DRB Application No.: 09DRB-70252 Project # 1004510
 Project Name: Montgomery Heights Addition
 Agent: Evangel Christian Center Phone No.: _____

DEVELOPMENT REVIEW BOARD--SPEED MEMO

CITY OF ALBUQUERQUE
PLANNING DEPARTMENT
August 12, 2009
DRB Comments

RE: Tract N, Montgomery Heights Addition

PLAT OF  
**TRACTS N-1 AND N-2**  
**MONTGOMERY HEIGHTS ADDITION**  
 WITHIN SECTION 35, T.11N., R.3.E, N.M.P.M.  
 CITY OF ALBUQUERQUE  
 BERNALILLO COUNTY, NEW MEXICO  
 JULY 2009

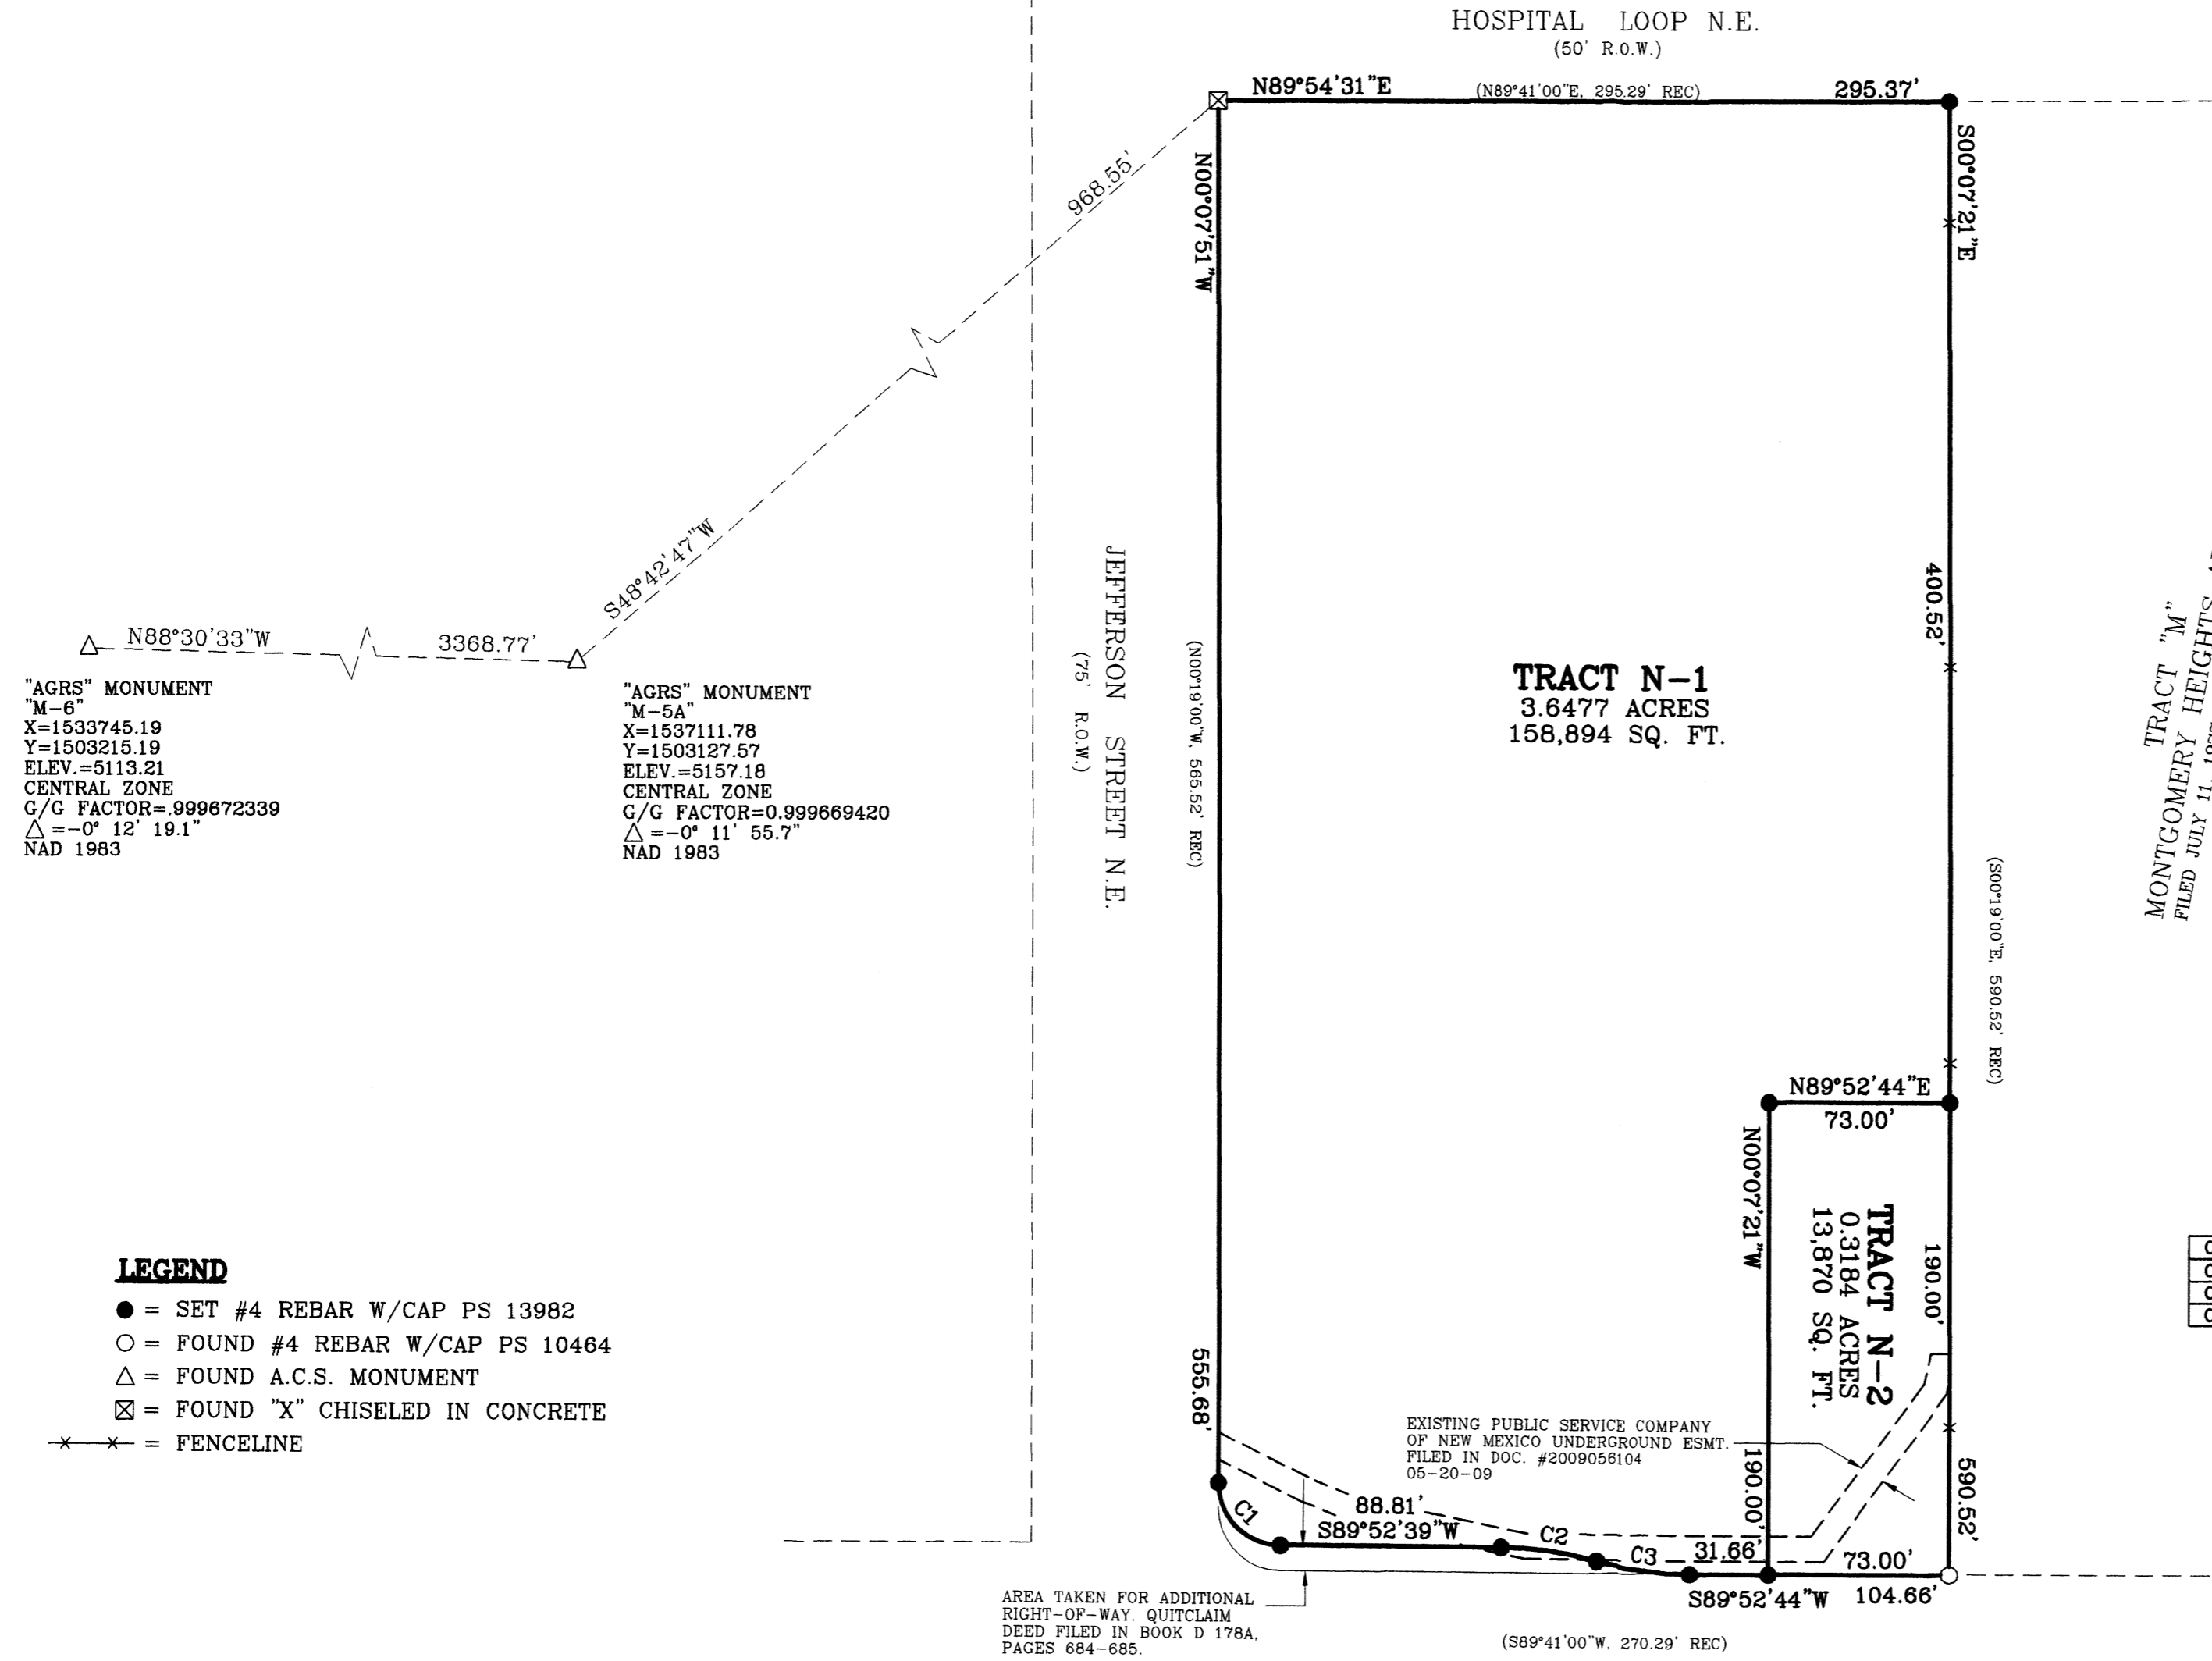
Albuquerque Need cross-lot drainage easement.

An exhibit is needed which shows the setback(s) of the building(s) to the proposed property line.

Reciprocal access, drainage, and parking easements will be needed. A Solar Note will be needed on the plat (consistent with Section 14-14-4-7 of the Subdivision Ordinance) which is specific to this type of request, i.e. use the words "THIS PLAT" (rather than the words "REQUESTED FINAL ACTION") at the beginning of the note, and do not use the words "OR SITE DEVELOPMENT PLAN FOR SUBDIVISION" at the end of the note. Also, please delete the Zoning Note (No. 5) from the plat.

Provide an exhibit showing the location of sidewalk and defining the distance from face of curb to the property line. Right of way dedication may be required.
Per the *Development Process Manual*, Table 23.3.3, the right of way at the intersection of a local and an arterial roadway requires a radius of 30 feet (applies to intersection of Jefferson and Hospital Loop).
Per the *Development Process Manual*, Table 23.3.3, the right of way at the intersection of two arterial roadways requires a radius of 35 feet (applies to intersection of Jefferson and Montgomery).
A cross access easement is required.
